PLANNING APPLICATION CONSULTATION RESPONSE

Application Number:	3/2022/0588
Proposal:	Discharge of Conditions 10 (Surface Water Drainage) and 11 (Surface Water Pollution Prevention) of planning application 3/2021/0076.
Location:	Queen Mary Terrace and Bridge Terrace, Mitton Road, Whalley, BB7 9JS

EXCEEDANCE ROUTE
LAYOUT

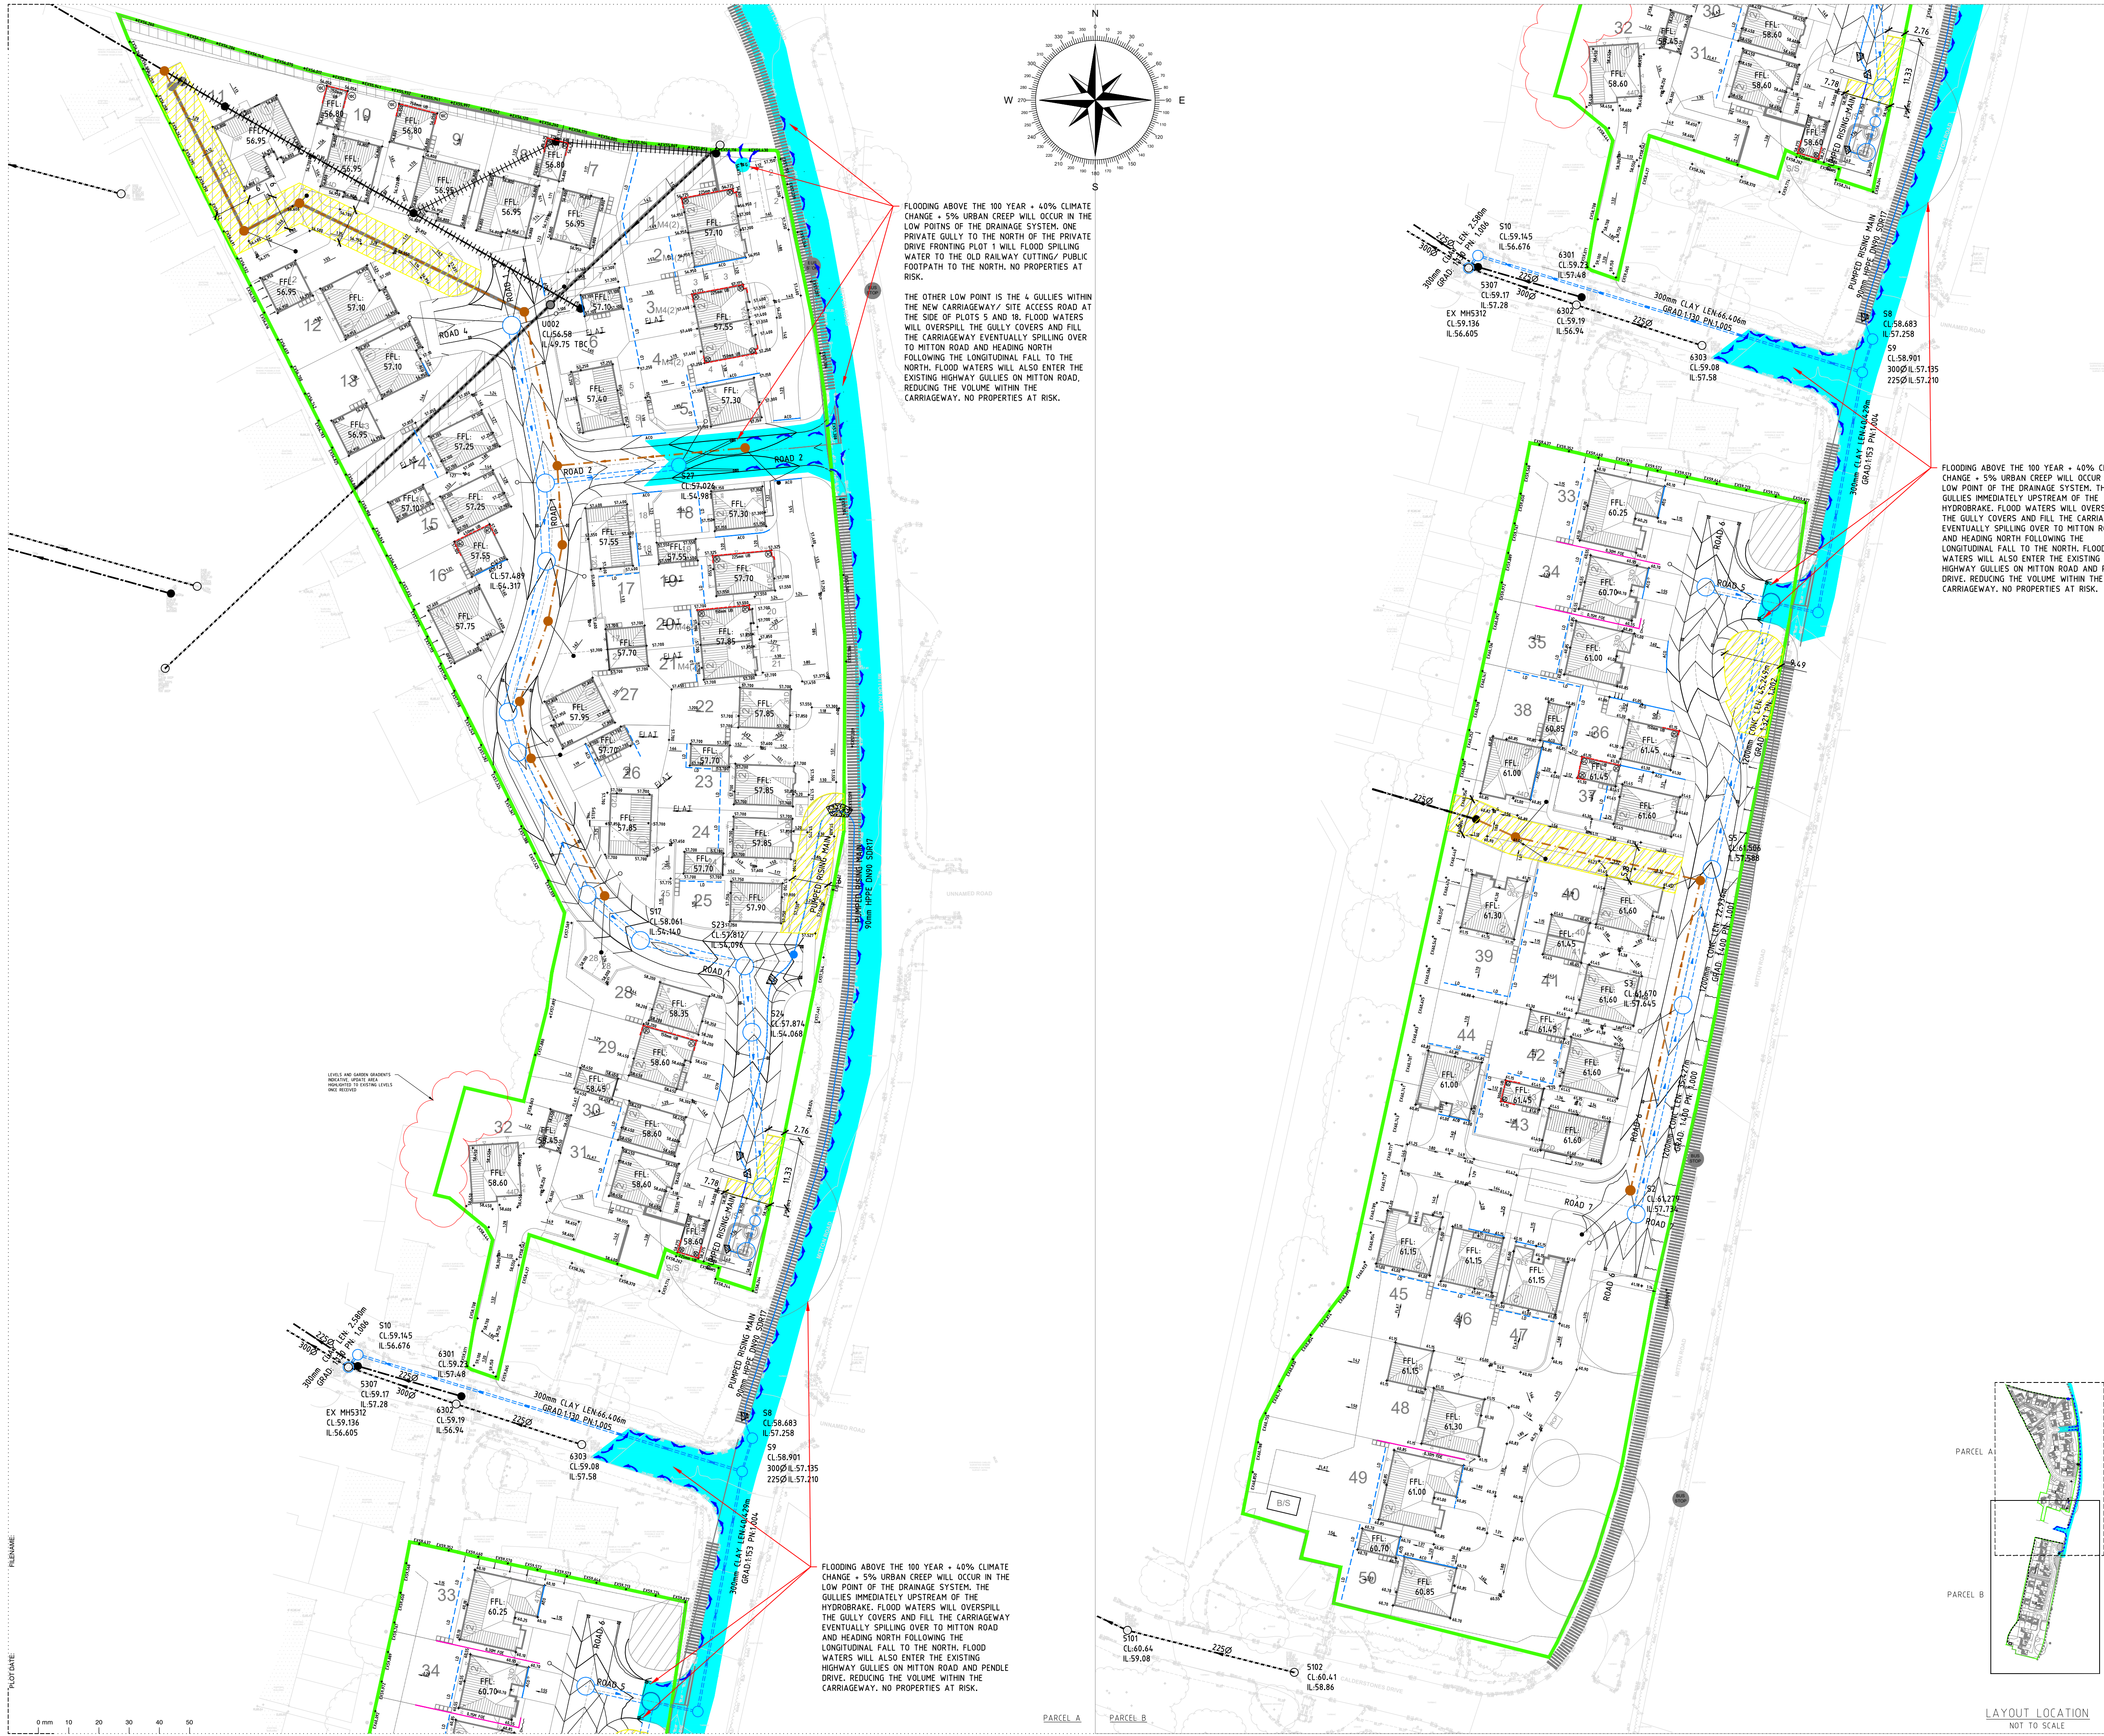
- The applicant has failed to provide a flood water exceedance route. This is to ensure that flows resulting from rainfall in excess of a 1 in 100 year rainfall event are managed in exceedance routes that minimise the risks to people and property, as stated in Standard 9 of the DEFRA Technical Standards. The Lead Local Flood Authority makes note to the applicant that S11 and S27 from Parcel A, show a flood risk in a 100 year event and the stresses the importance of an exceedance route as these manholes show cover levels lower than the cover levels of S12, and at present indicate that if flooding were to occur at these points, the surface water would pond due to surface water not being able to travel uphill.
